Our reference: DOC21/121543-38

17 March 2021

**Planning Referral – Aurelia Metals Ltd for Peak Gold Mines Pty Ltd  
State Significant Development SSD 10419 – Request for additional information**

Peak Gold Mines
New Cobar Complex Project
Air quality impact assessment
Figure B.1

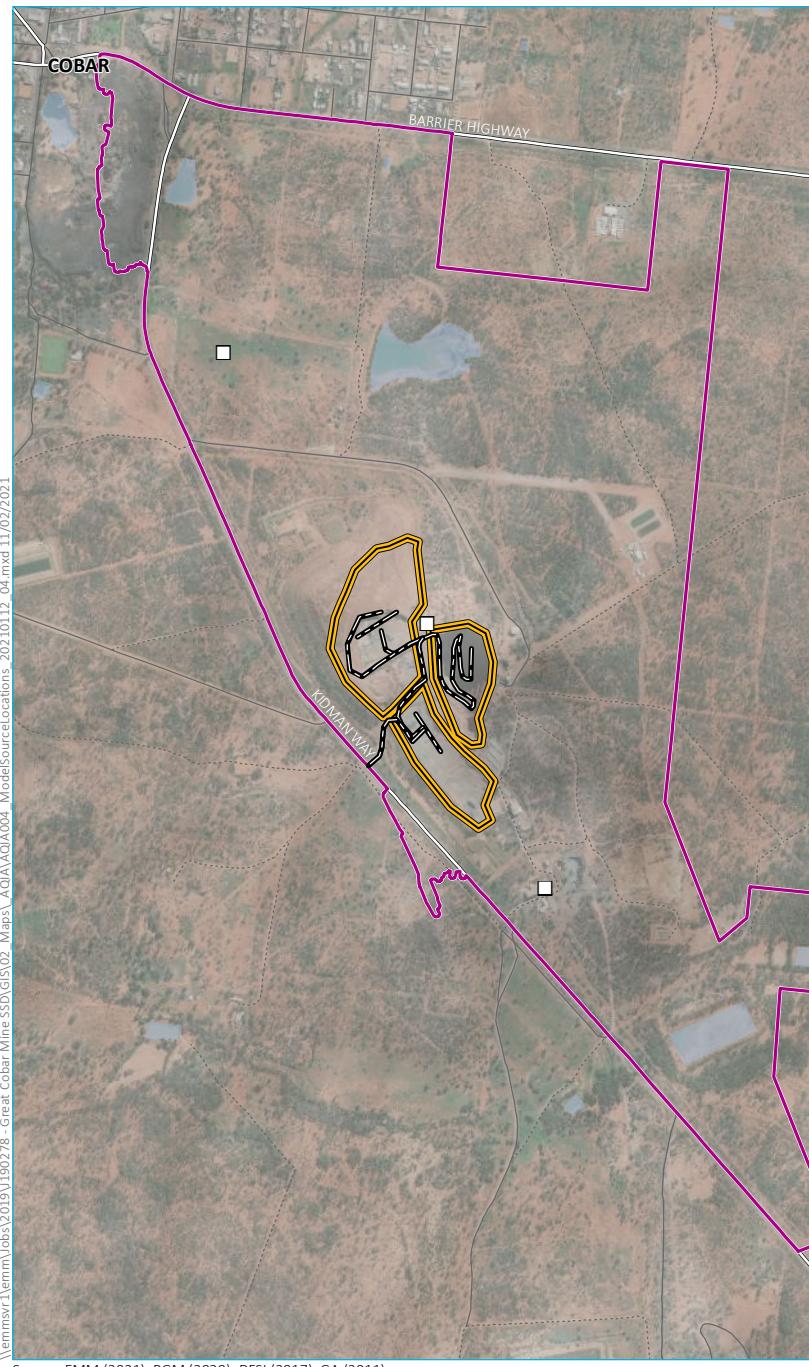
Based on Figure B.1 in the AQIA, the EPA understands that a number of sources representative of different activities have been combined and modelled as one source. For instance, although it is not clear, it is likely that loading, unloading and wind erosion activities at the New Cobar complex were potentially modelled as either a combined area or a combined area line source. Whilst the EPA recognises the merits of the approach, detailed information is required to allow for a robust and

- Providing a summary of individual modelled sources and their corresponding parameters (e.g. emission rates, initial vertical dimension -if used-, side length, aspect ratio, release heights, etc);
  - In the case where various sources were combined into one modelled source, provide a segregated list of the activities included in the modelled source;
  - In the case various sources were combined into one modelled source, provide detailed discussion on how the 'combined' total emission rate was estimated and how it accounts (where applicable) for any potential differences in times of the day each activity is proposed to be undertaken; and
  - Including any other relevant information that is not specified in points a -c above.
6. The EPA requests that the Proponent revises the AQIA to benchmark the proposed mitigation measures against best practice dust control measures.
